KIRKLEES METROPOLITAN COUNCIL INVESTMENT & REGENERATION SERVICE

DELEGATED DECISION TO DETERMINE PLANNING APPLICATIONS

Reference No:	2022/62/90514/W
Site Address:	75, Imperial Road, Edgerton, Huddersfield, HD1 4PG
Description:	Erection of single storey rear extension and external alterations
Recommending Officer:	Lucy Taylor

Officer Report.

Drawing No  
PL03

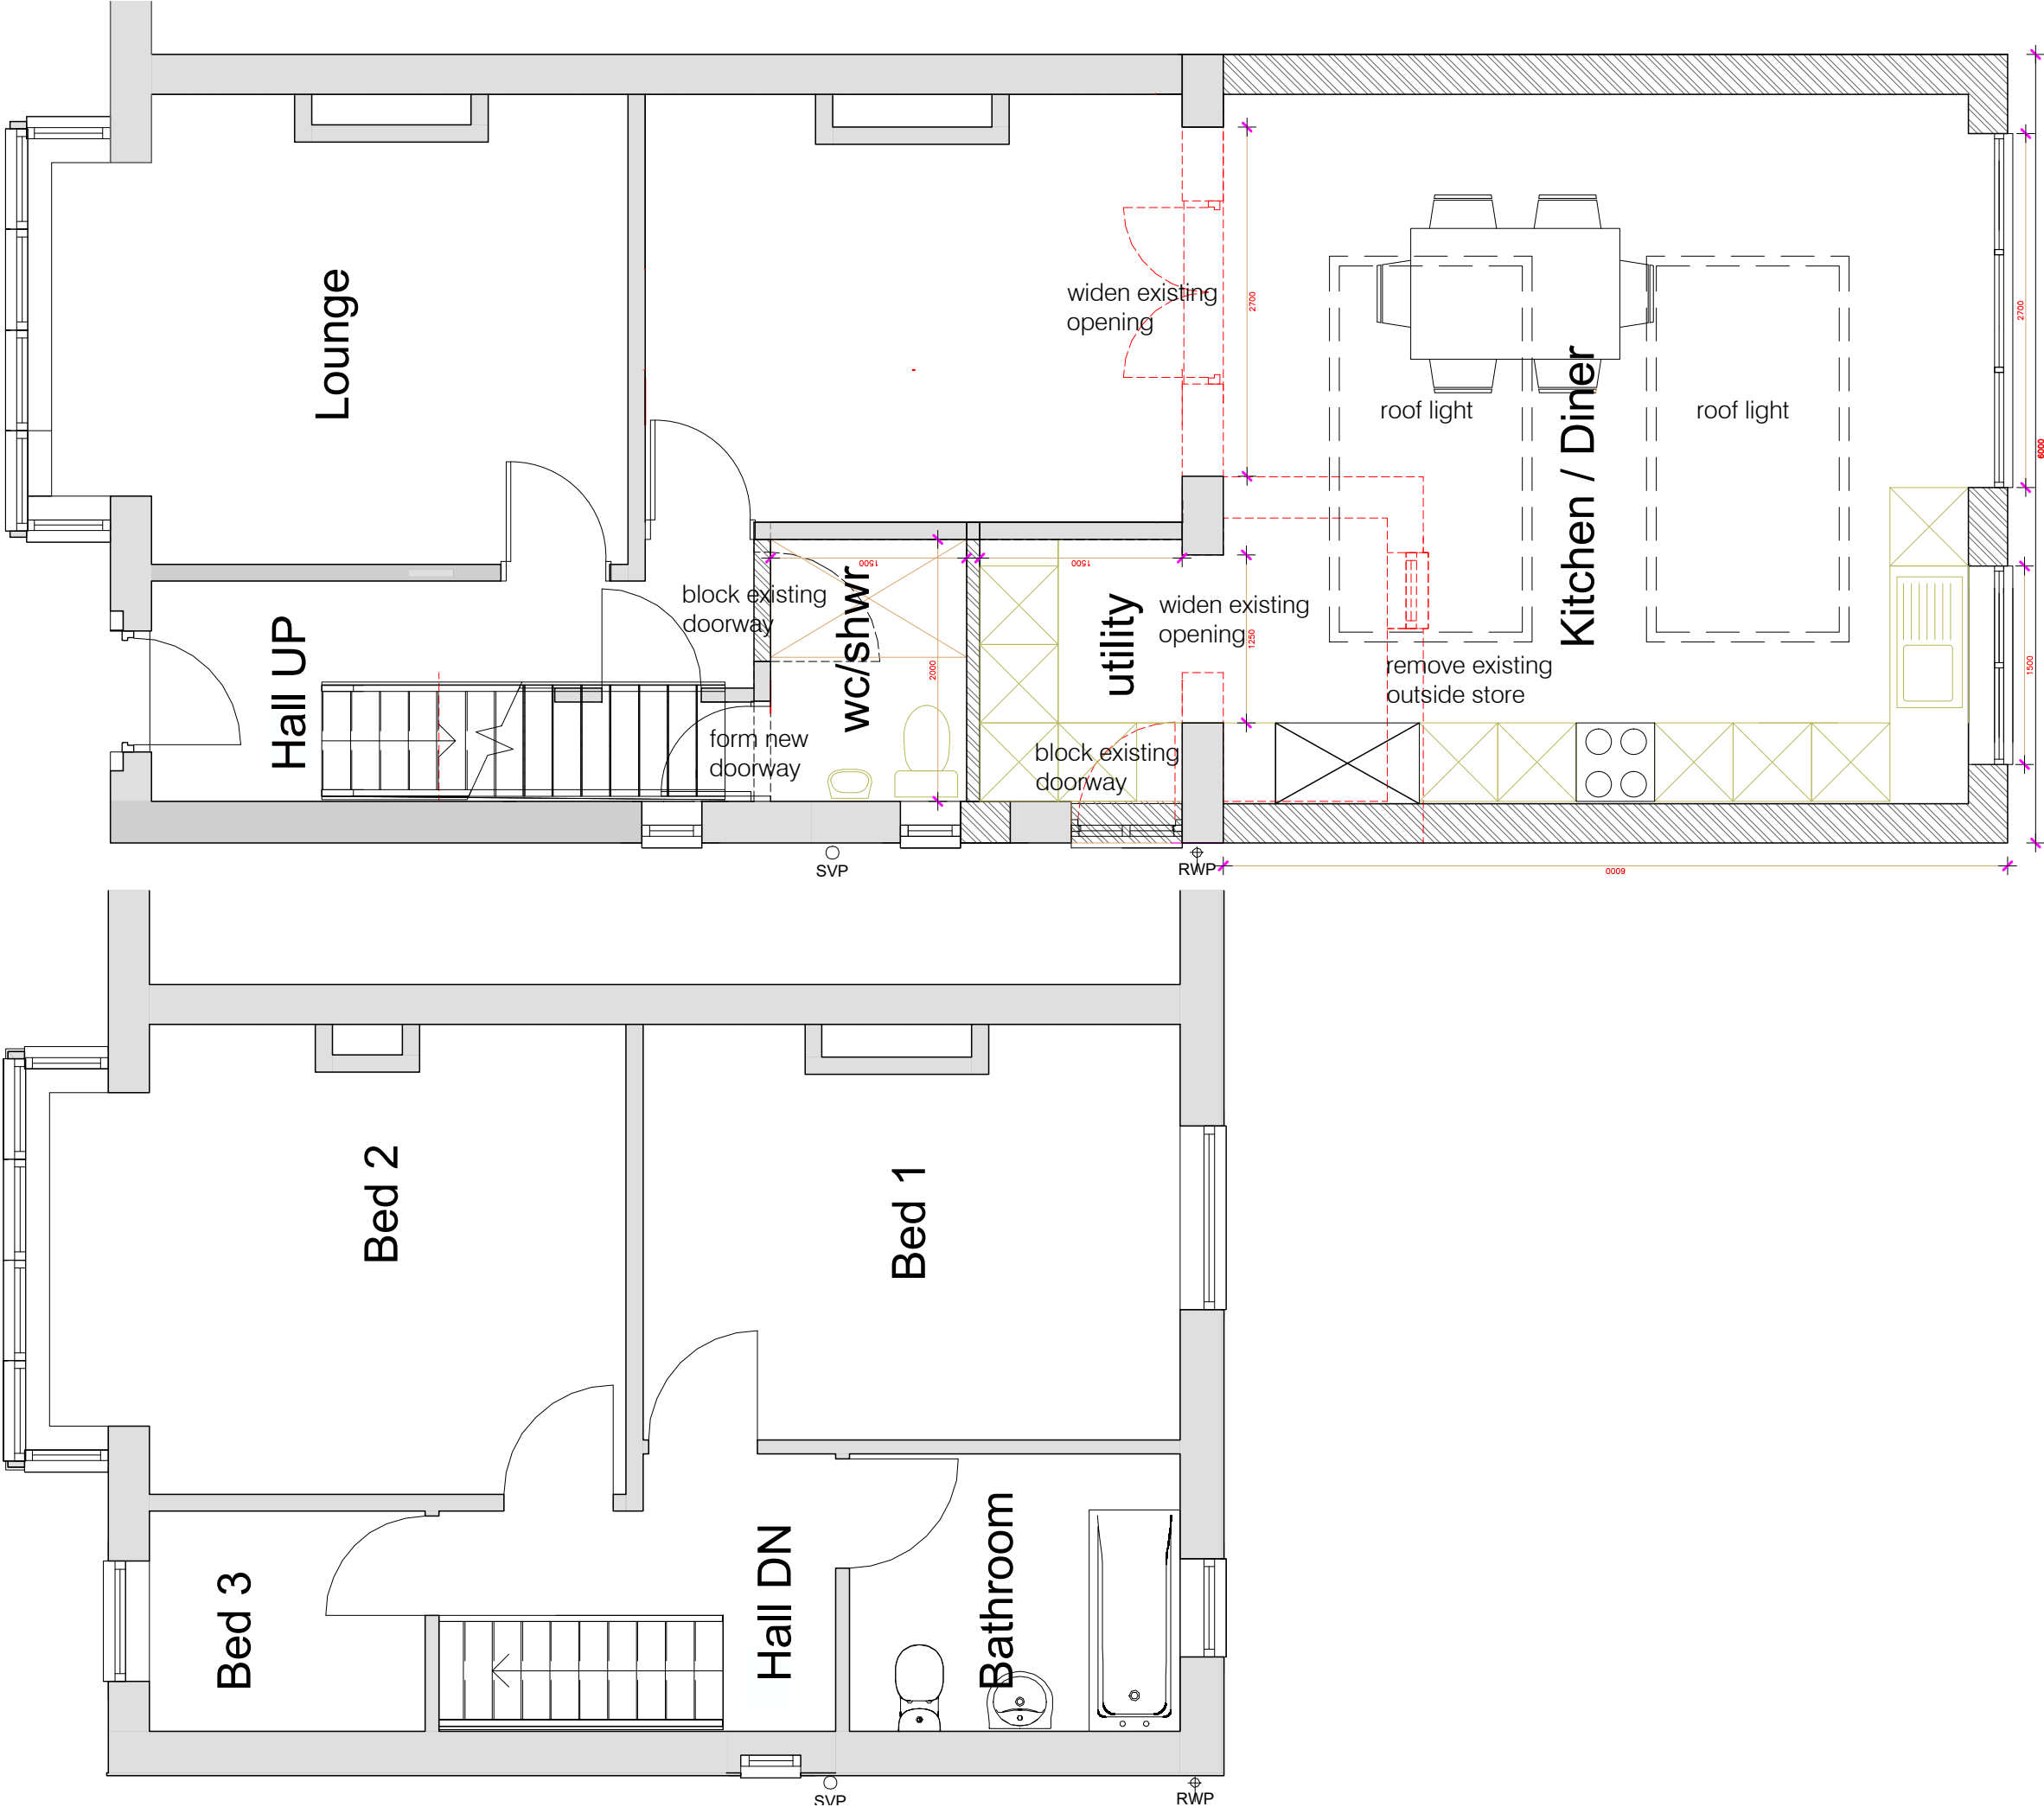
From a visual amenity perspective, the impact of the proposed rear extension to 75 Imperial Road having a total projection of 6 metres, only 2.5 metres less than the entire length of the host property is not considered to be subservient in relation to the size of the original dwellinghouse.

The extension would take up a large extent of rear garden amenity space at the property following construction. In addition, the width of the proposed extension aligns with the width of the host dwelling and adjoins the neighbouring boundary to the west.

In addition, the extension would fail to comply with the 45-degree rule, as set out in the Council's adopted House Extensions and Alterations SPD. The 6-metre projection to the proposed extension, and the lack of separation distance from the shared boundary, means that the extension fails to meet the 45-degree rule in relation to the glazed doors to the rear elevation of No. 77 Imperial Road. This is particularly important, as based upon site visit analysis, it is likely that these windows serve a main habitable room within the interior of No. 77.

The case officer sought amended plans to the reduce the projection of the proposed rear extension from the rear elevation of the dwelling, from 6 metres down to 3 metres, to comply with the design requirements of single storey rear extensions as set out on page 24 of the Kirklees Council House Extensions and Alterations SPD. In addition, the officer sought that the extension be set 1 metre away from the adjoining neighbouring property, for reasons of SPD compliance and residential amenity. The case officer allowed the applicant a time period of 18 days to submit amended plans.

Drawing No	PL08
------------	------

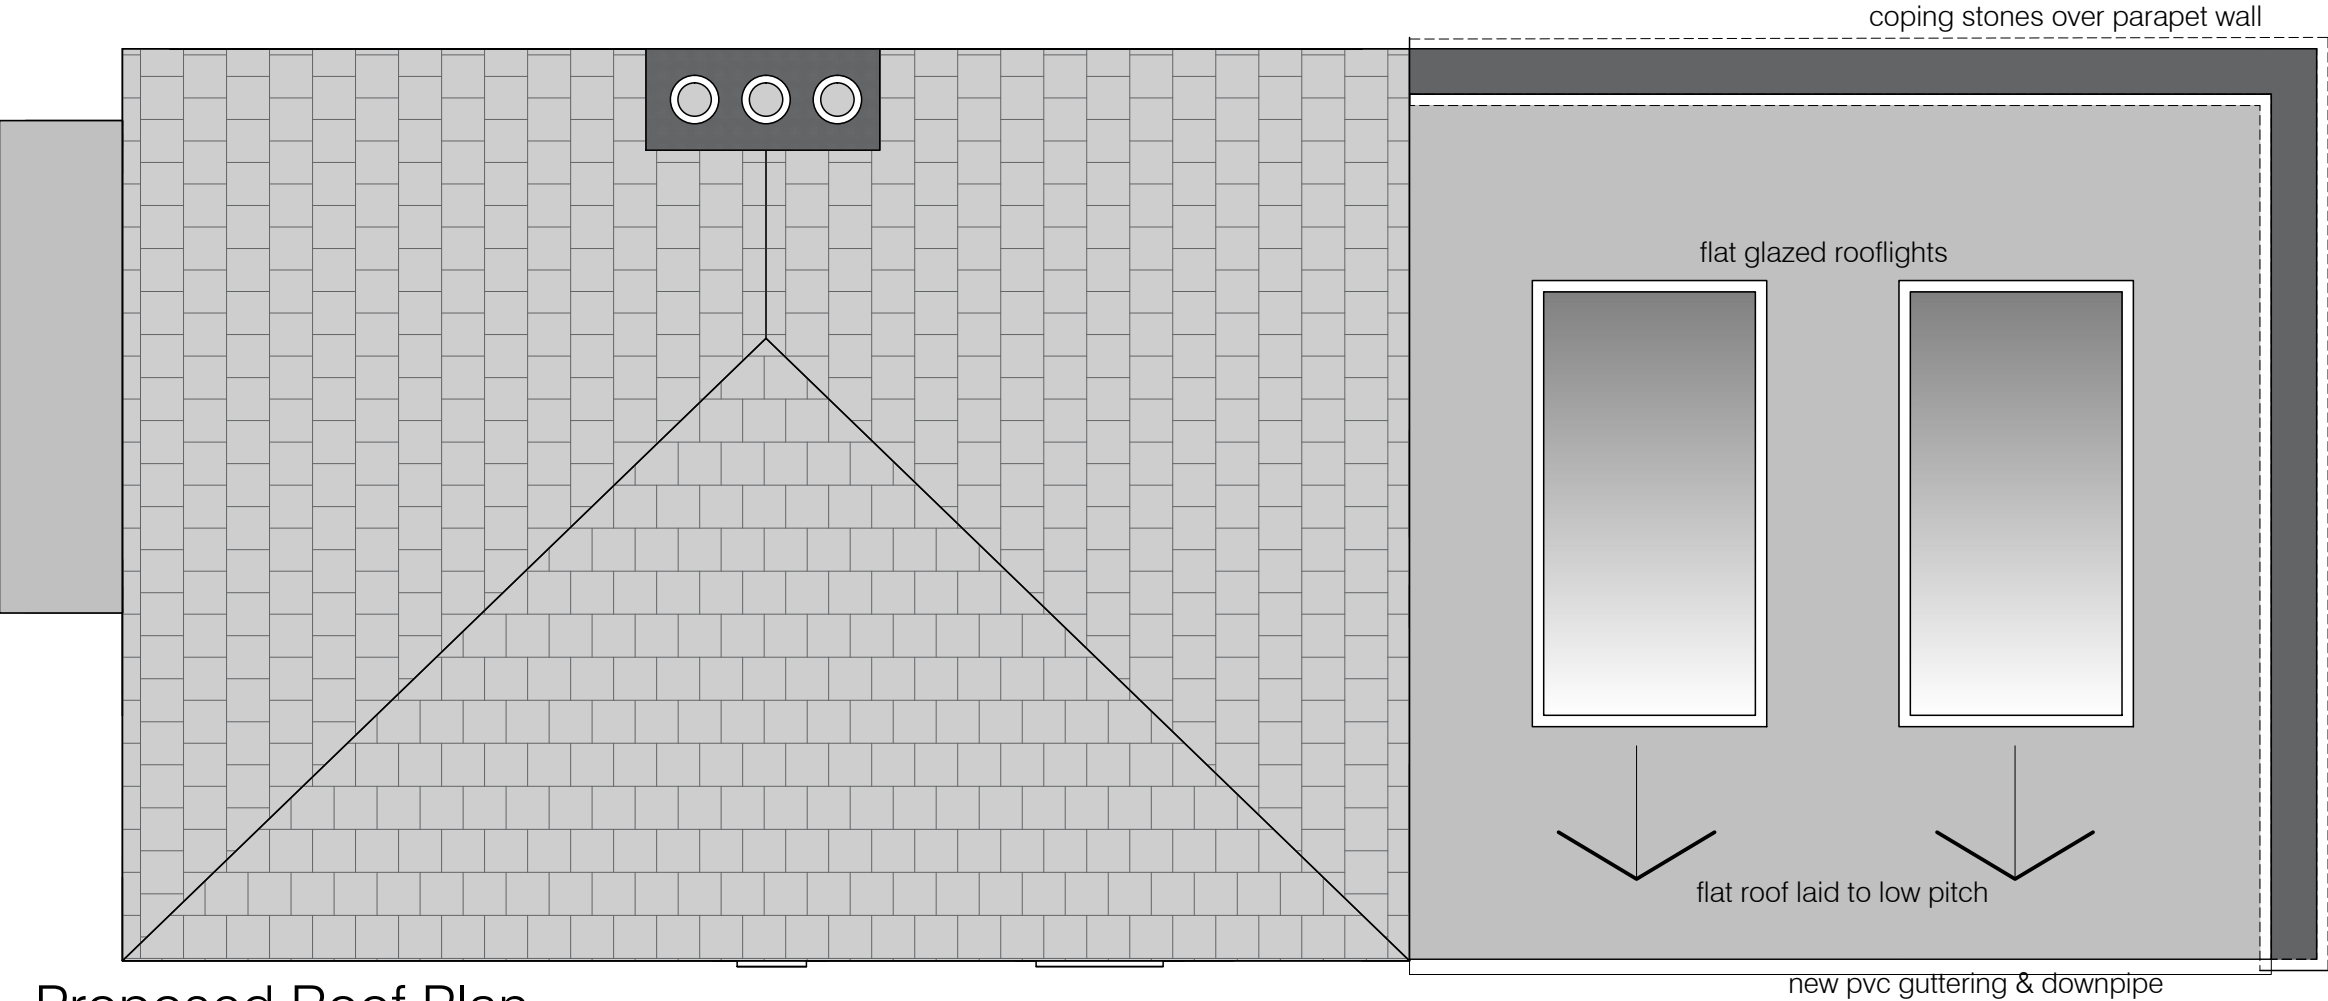
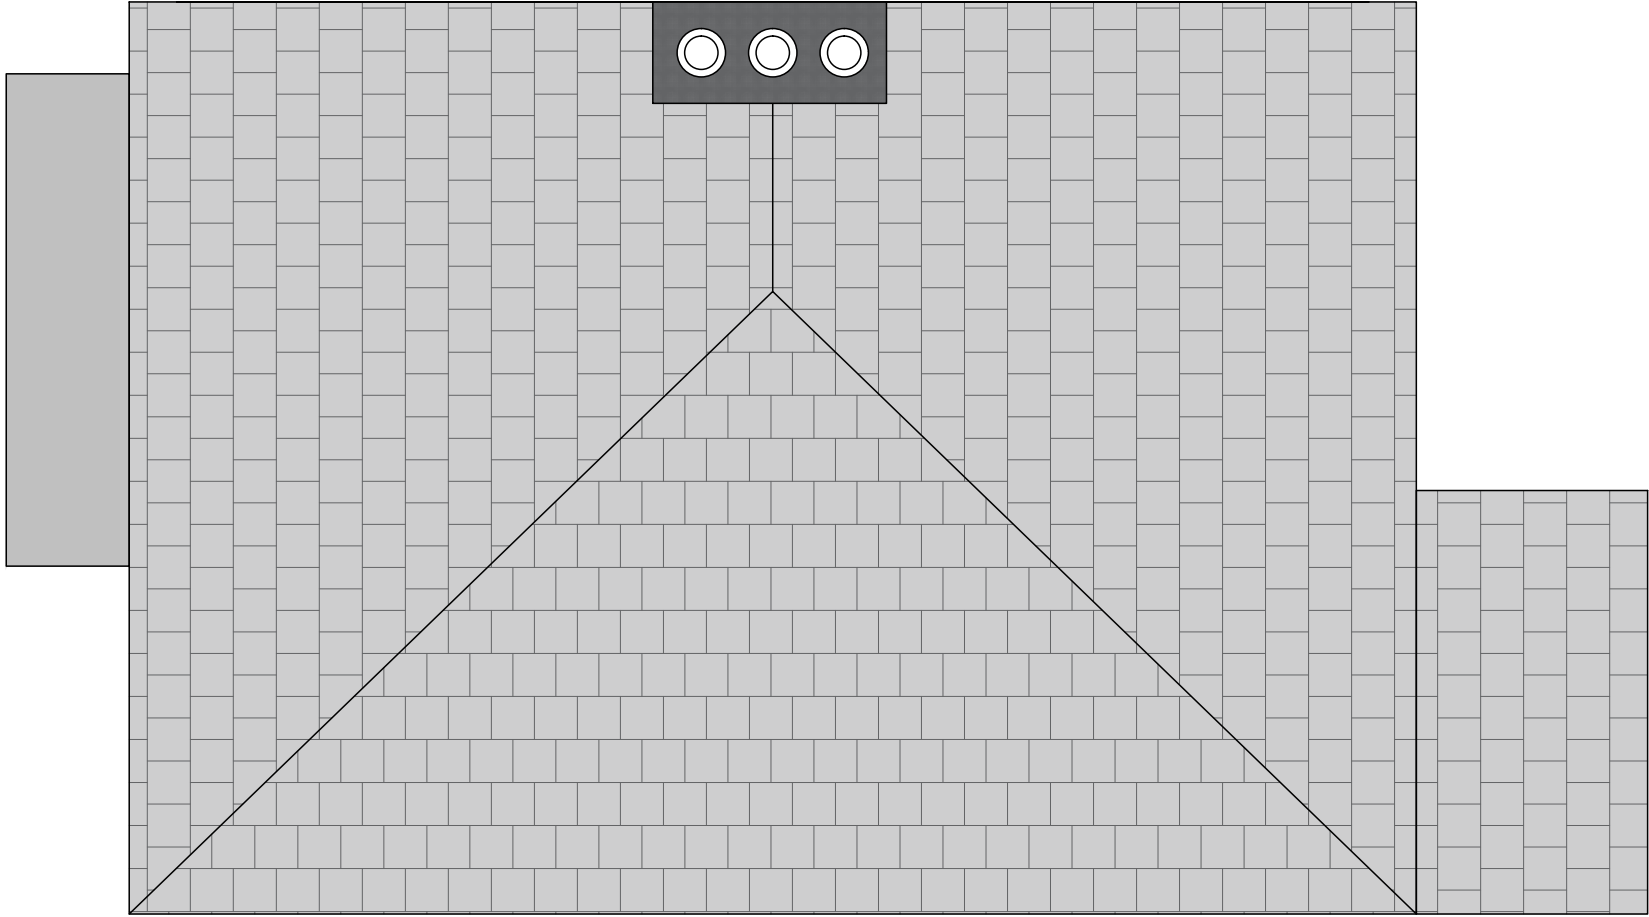
The flat roofing structure is considered to create an undue extent of bulking and massing, with a significant height that sits just below the first-floor window of the original rear elevation of the property. This height in conjunction with the scale of the development is considered to be out of character with the host property from a visual amenity perspective, contributing to the obtrusive

design of the extension, set below the eaves height of the original dwelling by only 1.9 metres. As a result, the extension is considered to have an incongruous appearance which is not subservient due to the overall size/scale and design of the development.
